**Consultation Response from Alan Smith,  
KC Waste Strategy (Refuse & Recycling)**

**2025/91184 land off, Bretton Street, Savile Town, Dewsbury, WF12 9BZ**

**Erection of two storey industrial unit (Use Class E(g)(iii)), with associated car park, service area  
and other associated works**

**Responding Ref: WPN 25 020**

Project No: 2024  
Enquiry 51  
Project Title: proposed site location (overlaid onto with survey contours)  
Reviewed By: MC  
Scale: 1:500 @A1 size  
Date: 7/1/2025

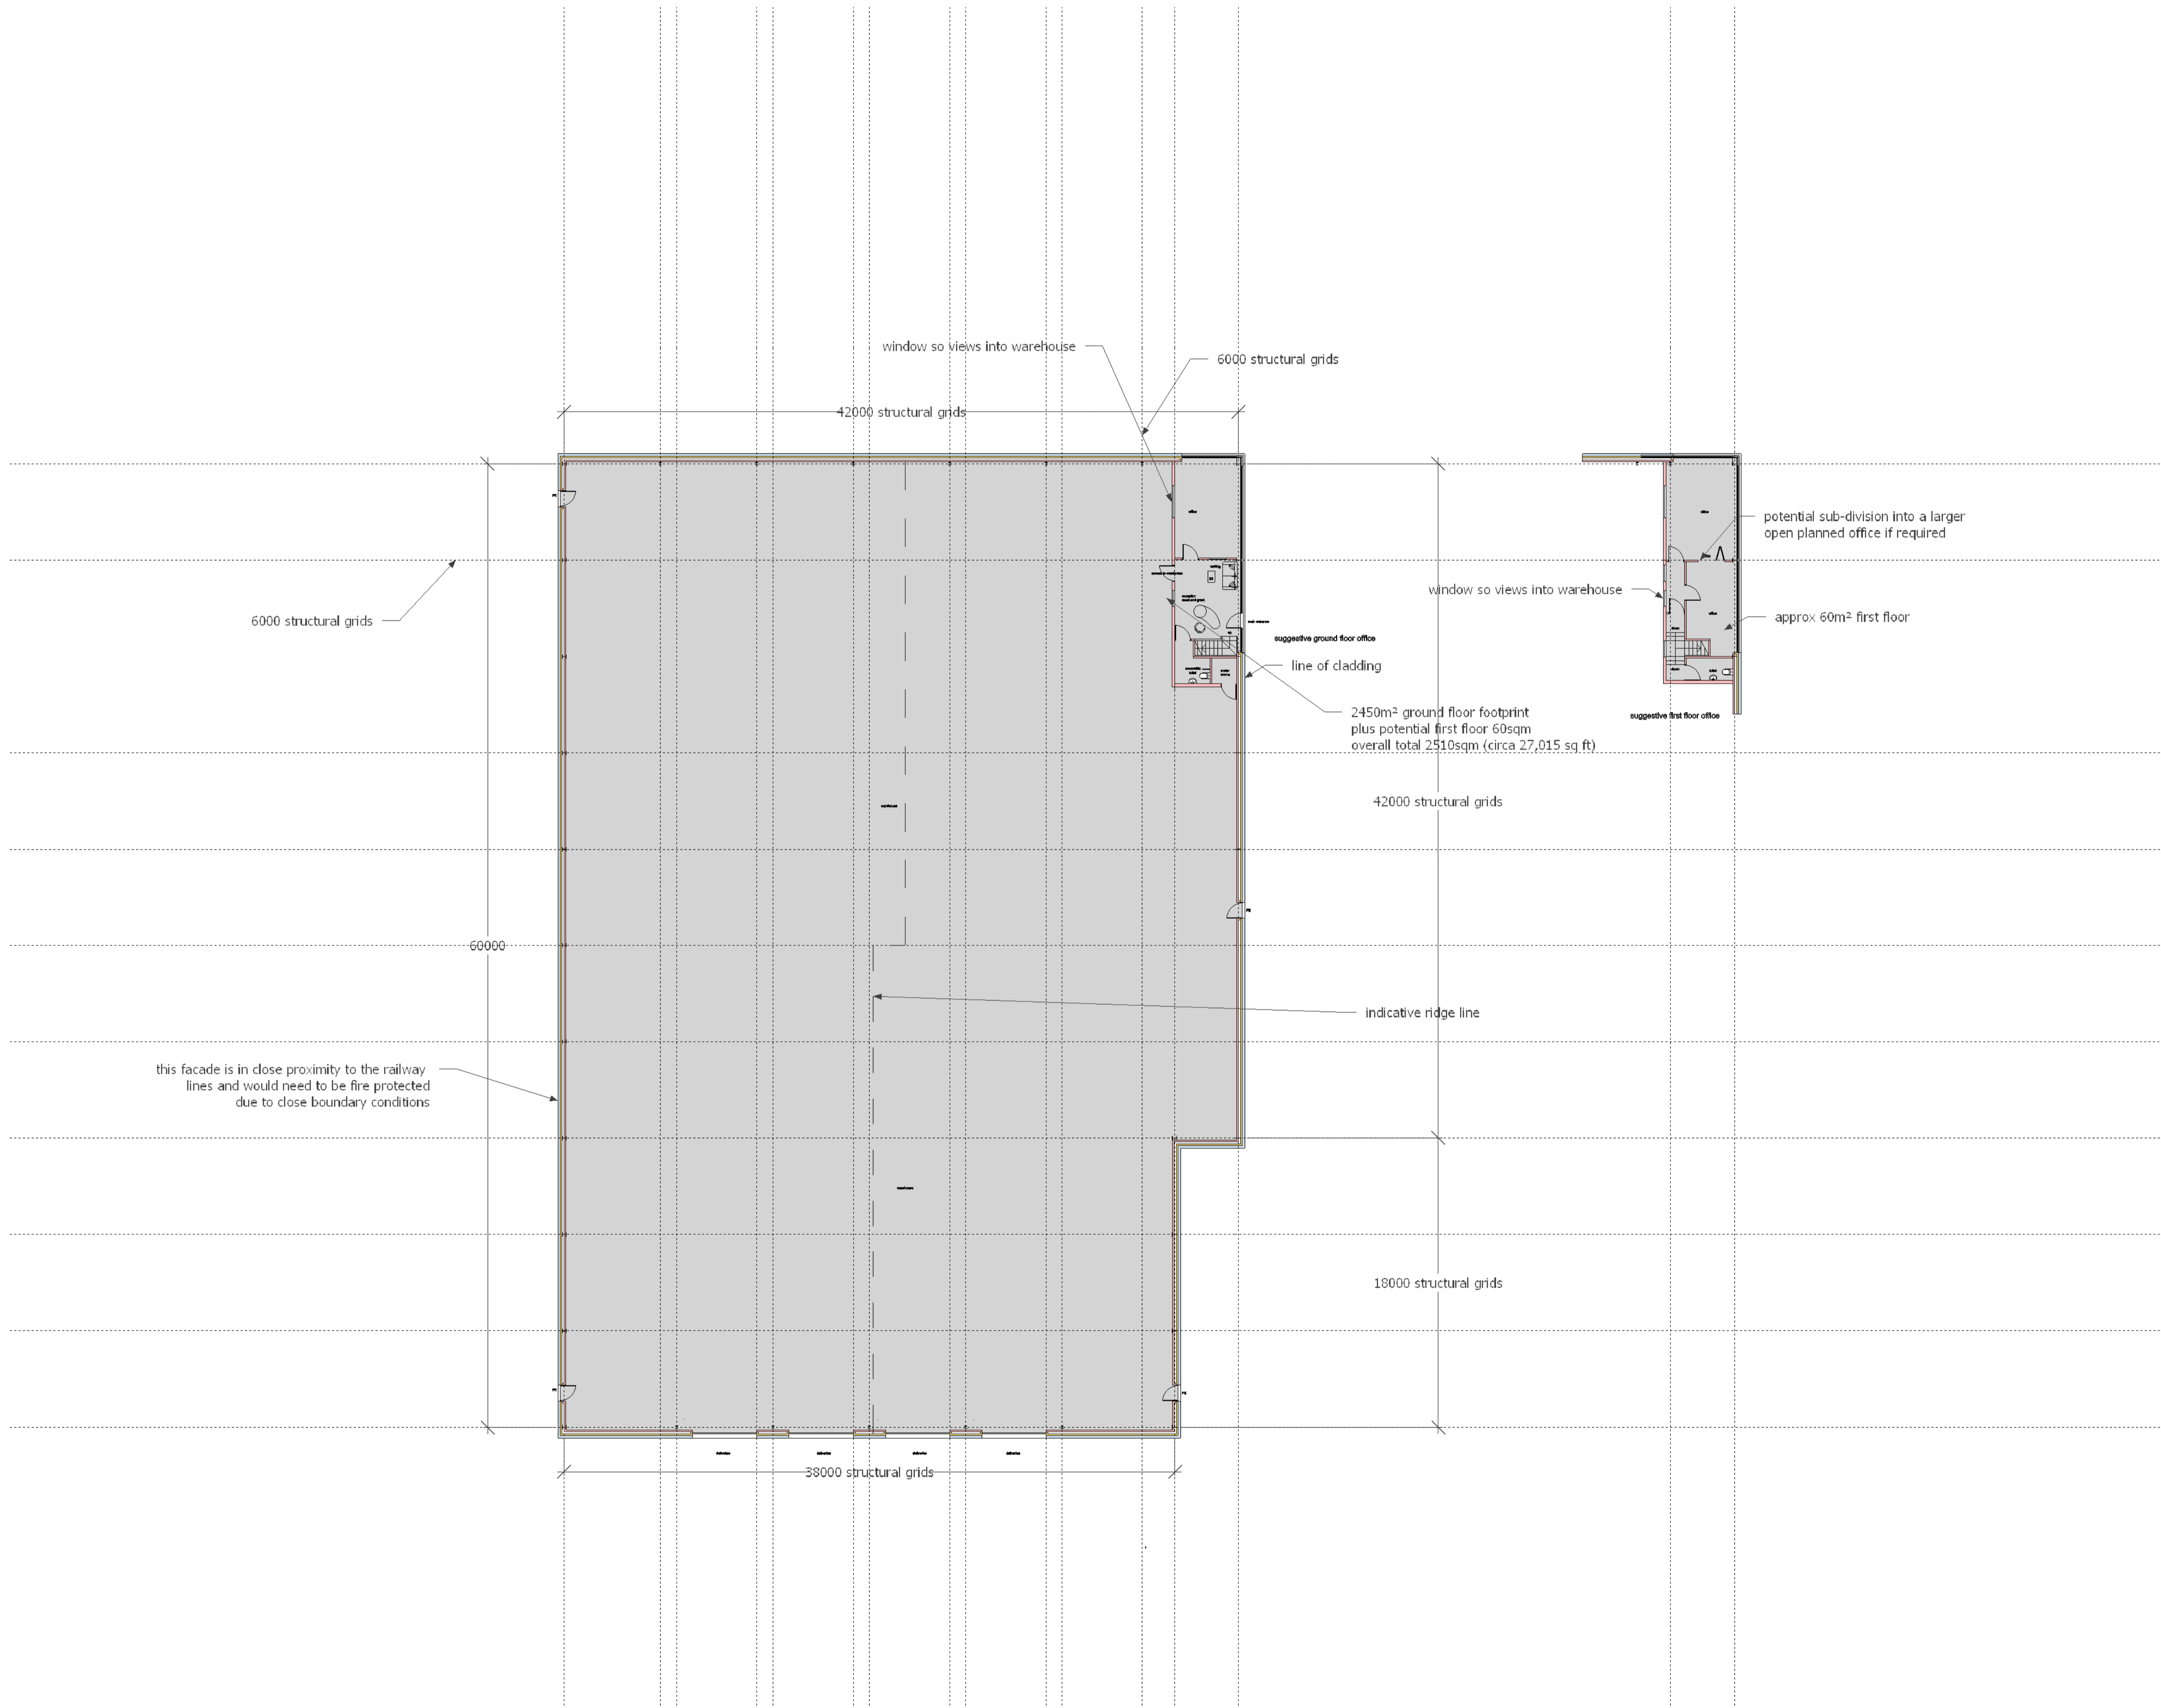
- The proposed bin store is approximately 3m x 4m. This should be of a sufficient size to accommodate a range of waste containers allowing for any extra containers to meet Simpler Recycling legislation.

- Waste storage presents a fire risk and should be carefully considered when undertaking a fire risk assessment. The proposed bin storage location is an acceptable

distance from any buildings.

- The bin compound shown in the south of the site is more than 6m away from the building. If not using skips or FEL bins, the drag out distance for wheeled bins from a bin store / premises to the refuse collection vehicle (RCV) should preferably be under 15m. Access to and from the bin storage area should be constructed to withstand point loading and movement, impacts of larger bins over time, and to resist future rutting, pitting, cracking or other such surface degradation that would impair bin manoeuvring. From the plan the bin store appears to be readily accessible with minimal drag out distances.
